# ATTACHMENT A

## RESPONSE TO SUBMISSIONS

CONCEPT PLAN & DRAFT PREFERRED PROJECT REPORT OBS.	RESPONSE
<b>1. Dept of Planning and Infrastructure</b>	
2. <i>Inadequate information - Lot 6</i>	Department advised appropriate to remove Lot 6 from PPR. PPR does not include Lot 6. Submissions concerning Lot 6 do not require further consideration.

EROSION & SEDIMENT CONTROL NOTES

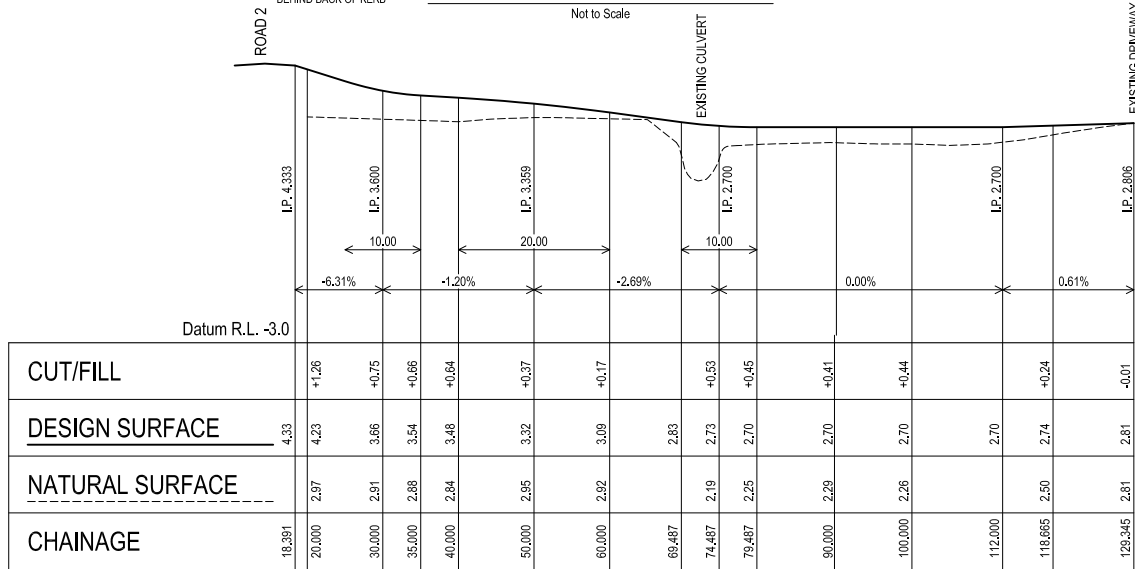
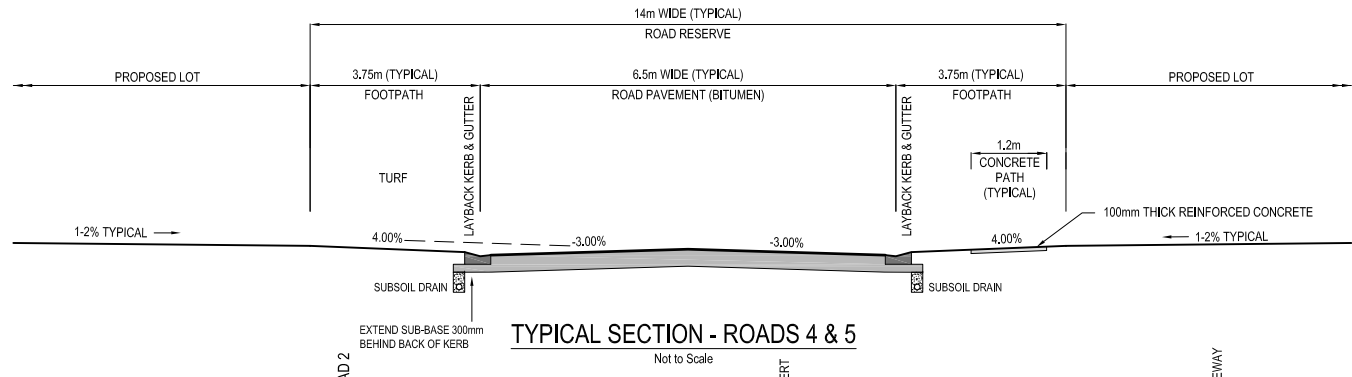
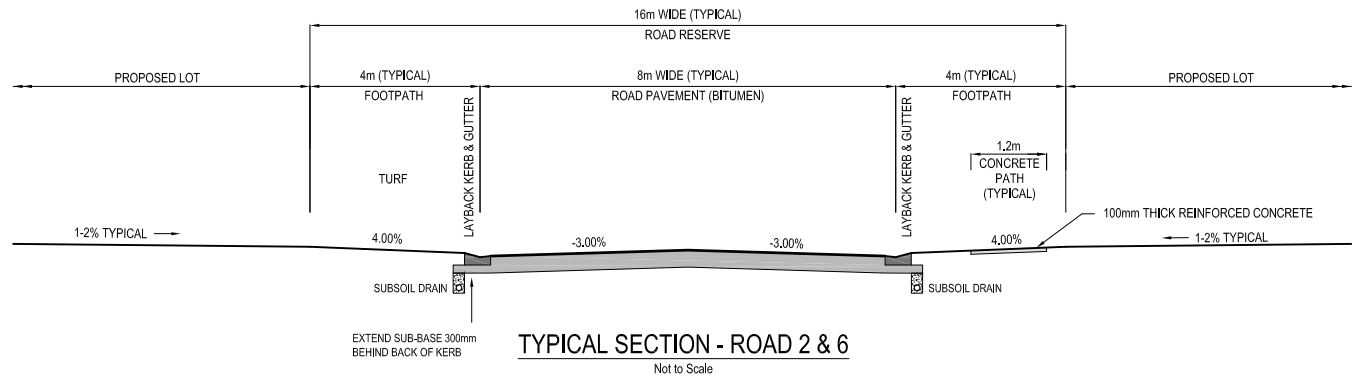
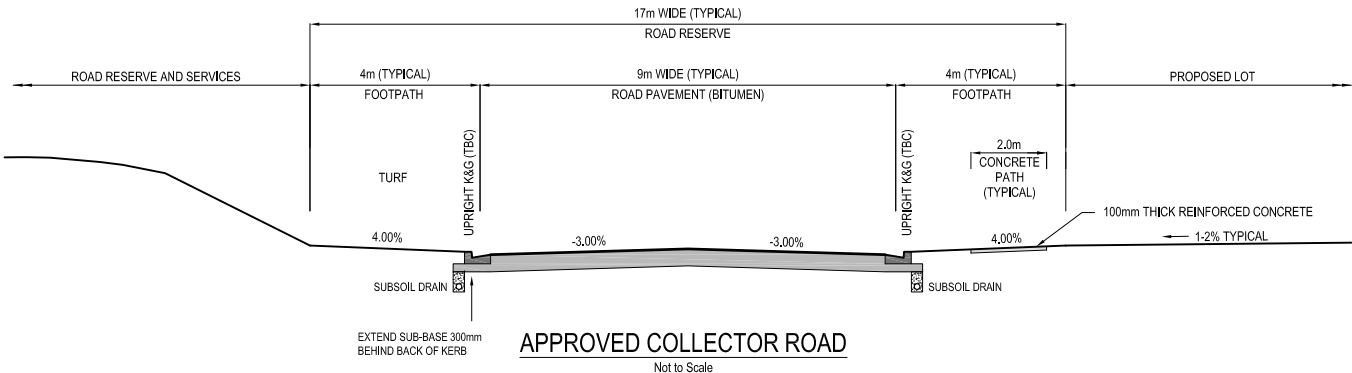
130. Objection 3 – additional stormwater onto Lot 6 from Lot 1 fill & removing trees in riparian zone for basins.	Stormwater is directed to the rear of proposed lots backing onto Lot 6 boundary and then directed eastwards via a swale, outside of Lot 6, to Moonee Creek.

CONCEPT ACCESS TO EXISTING DWELLING (LOT 2 DP 1097743)  
Scale Horizontal 1:500 Vertical 1:100

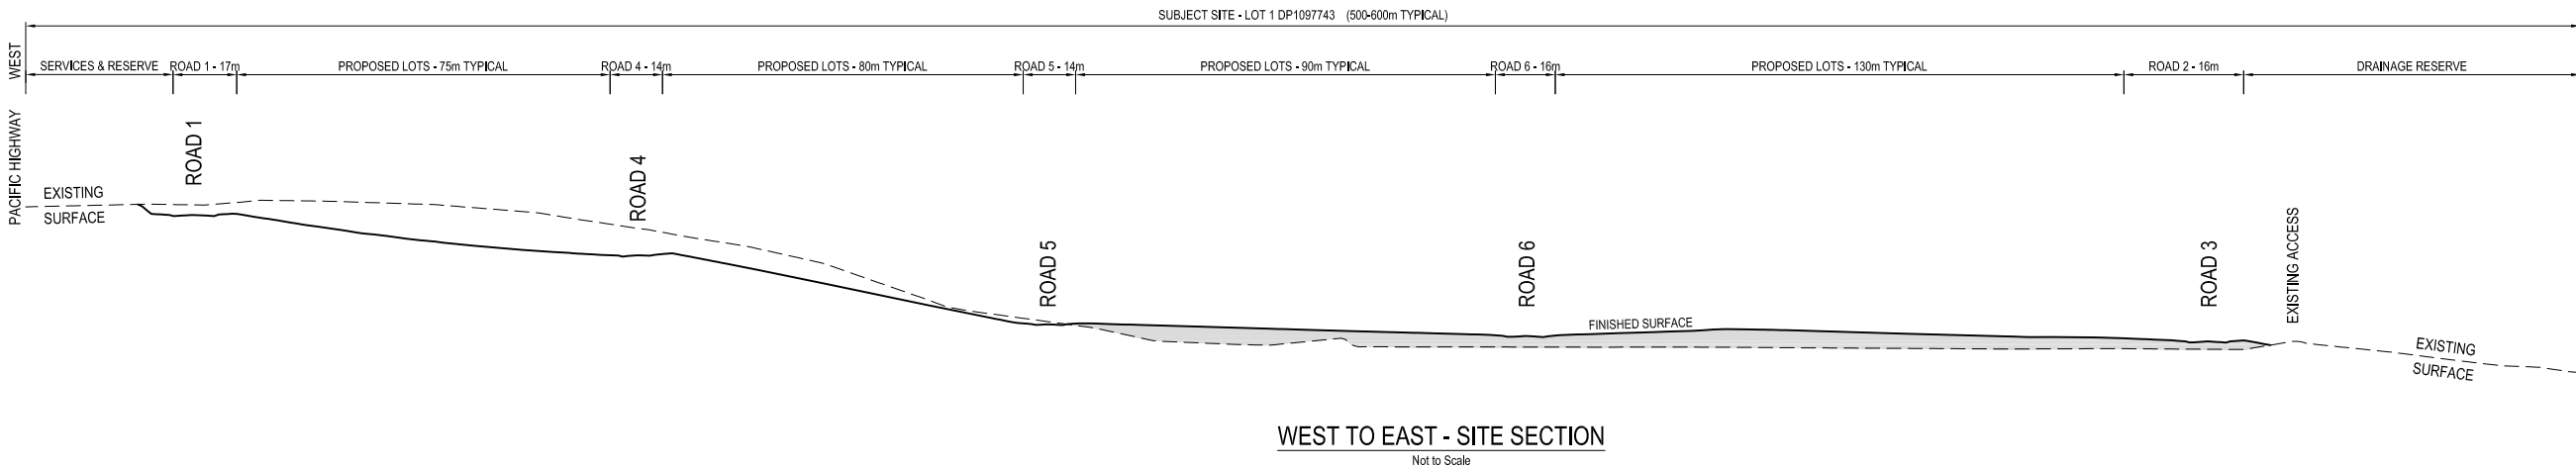
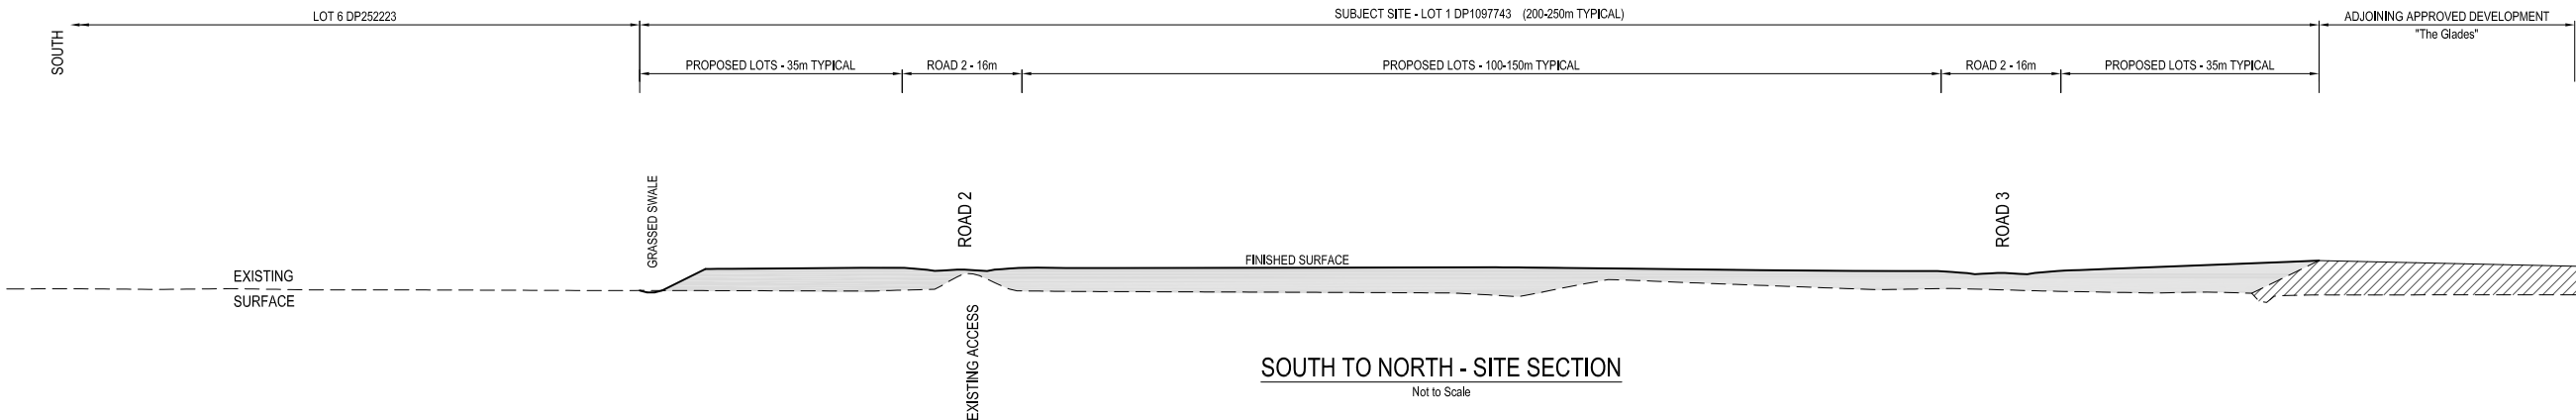
8. <i>Road profile required of access to Lot 2 required</i>	Refer Attachment B
9. <i>Buffer to be dedicated to council with a dedication plan provided</i>	Refer Figure 13
